RE: NOTICE OF EXHIBITION – SSD 7745 MOD 1, Site 18, SYDNEY OLYMPIC PARK

SOPA has reviewed the submitted modification request and wishes to raise the following matters in relation to the proposed development:

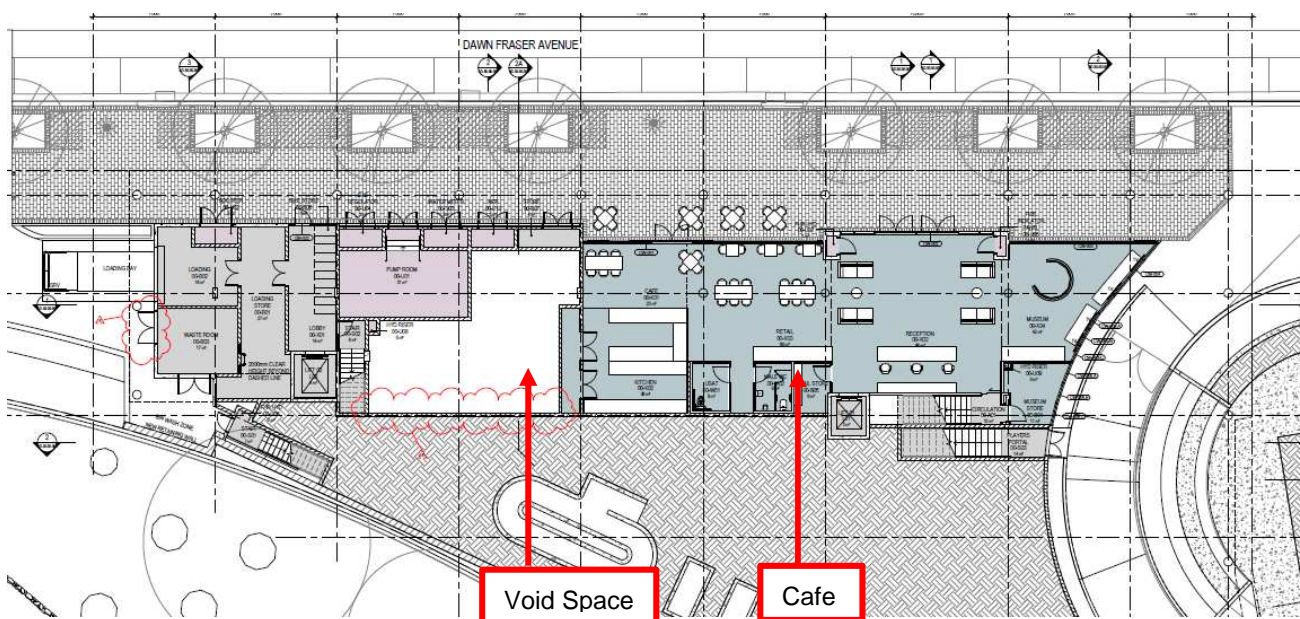
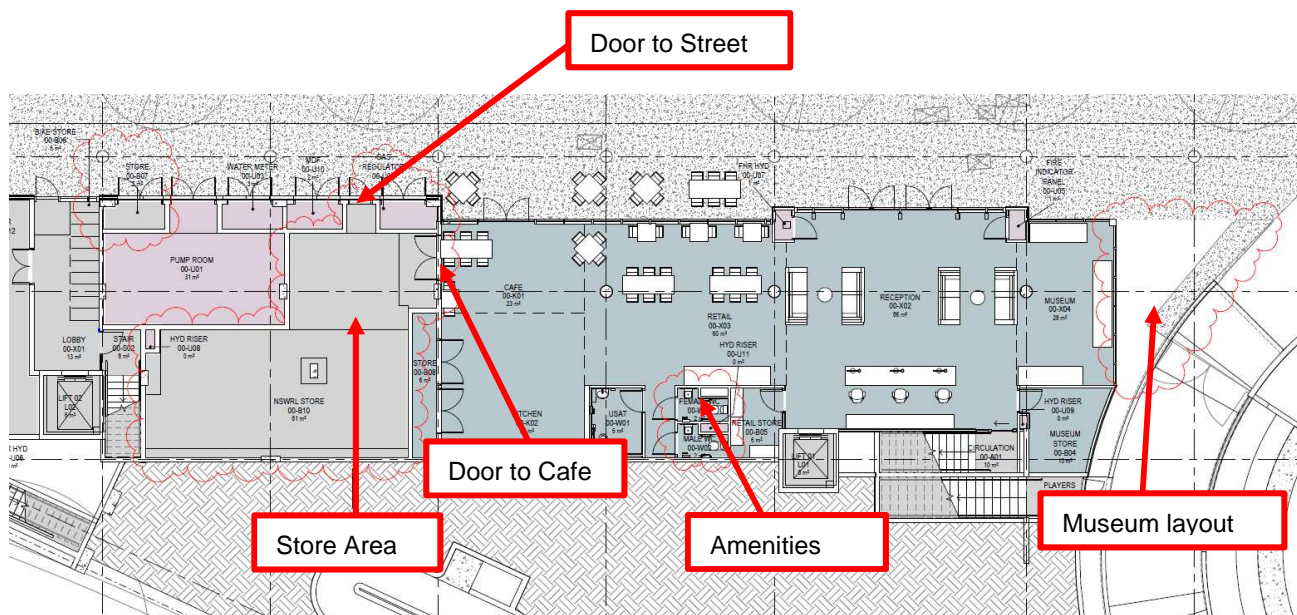
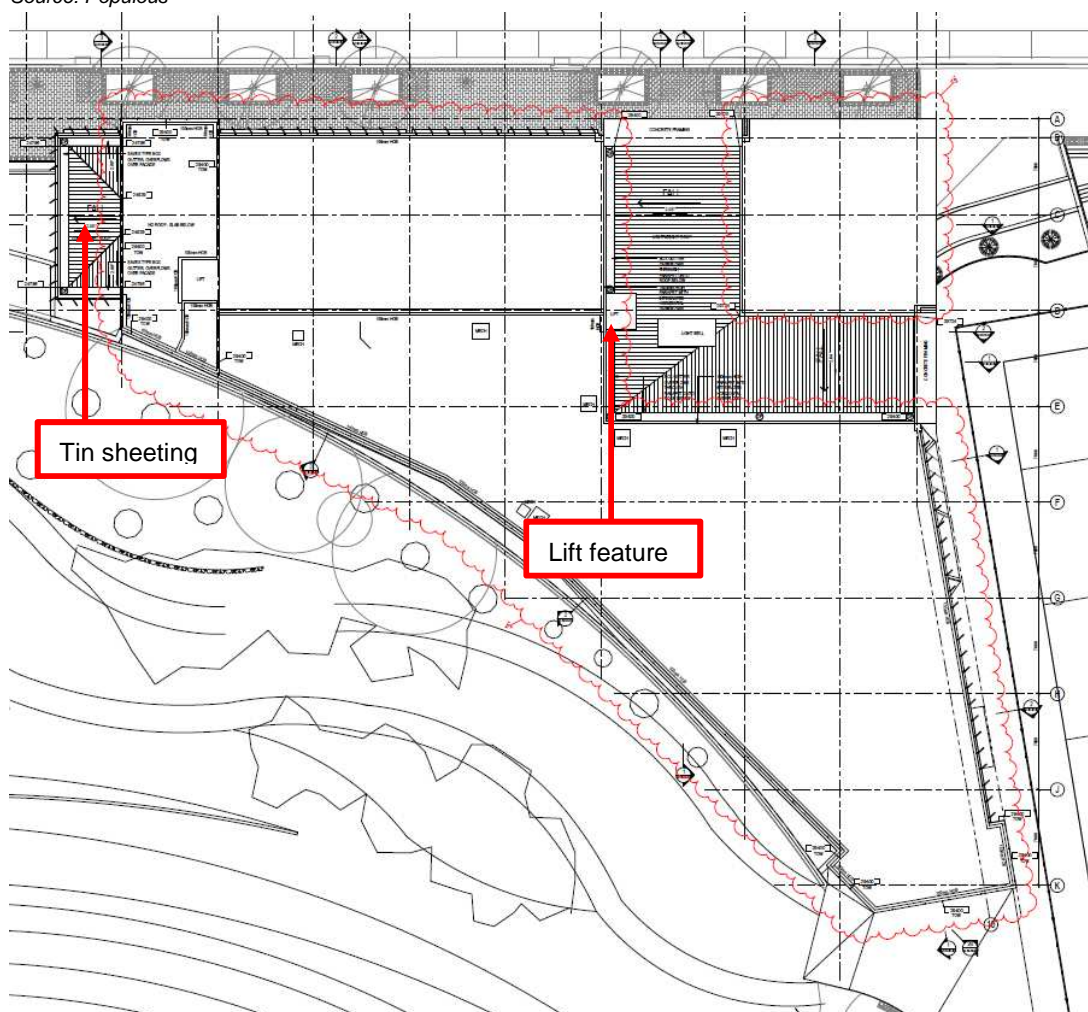
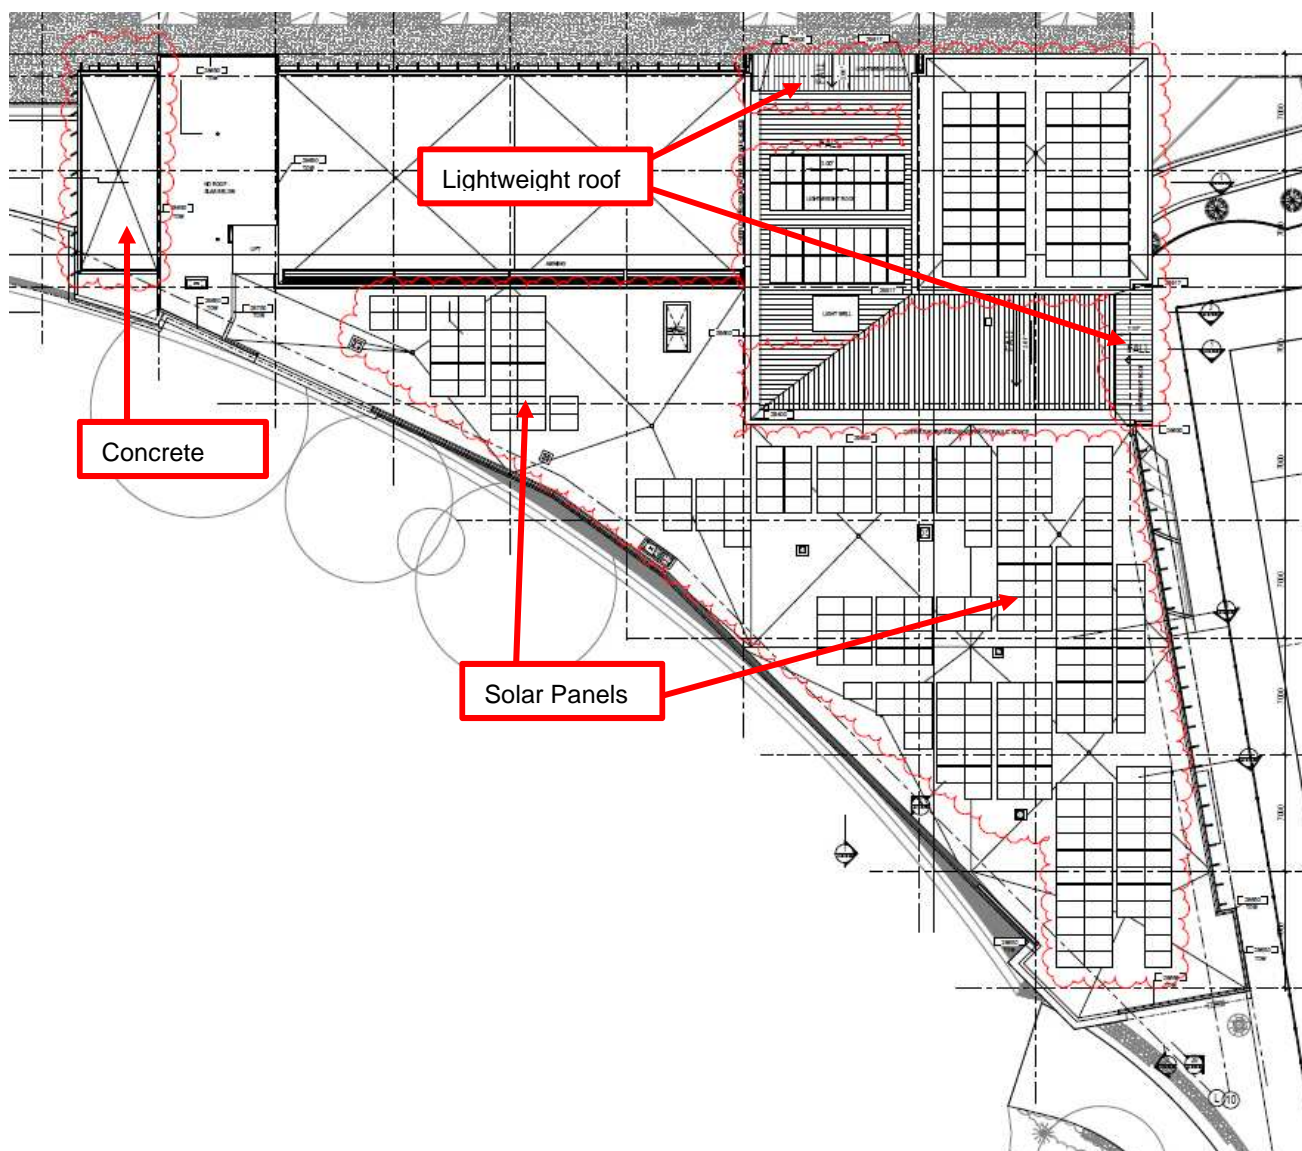
Although the proposed modifications are relatively minor in scale, they will change the footprint and external appearance of the building. Accordingly, amended elevations should be provided in addition to the amended floor plans to more accurately depict the extent and impact of the proposed modifications on the overall building.
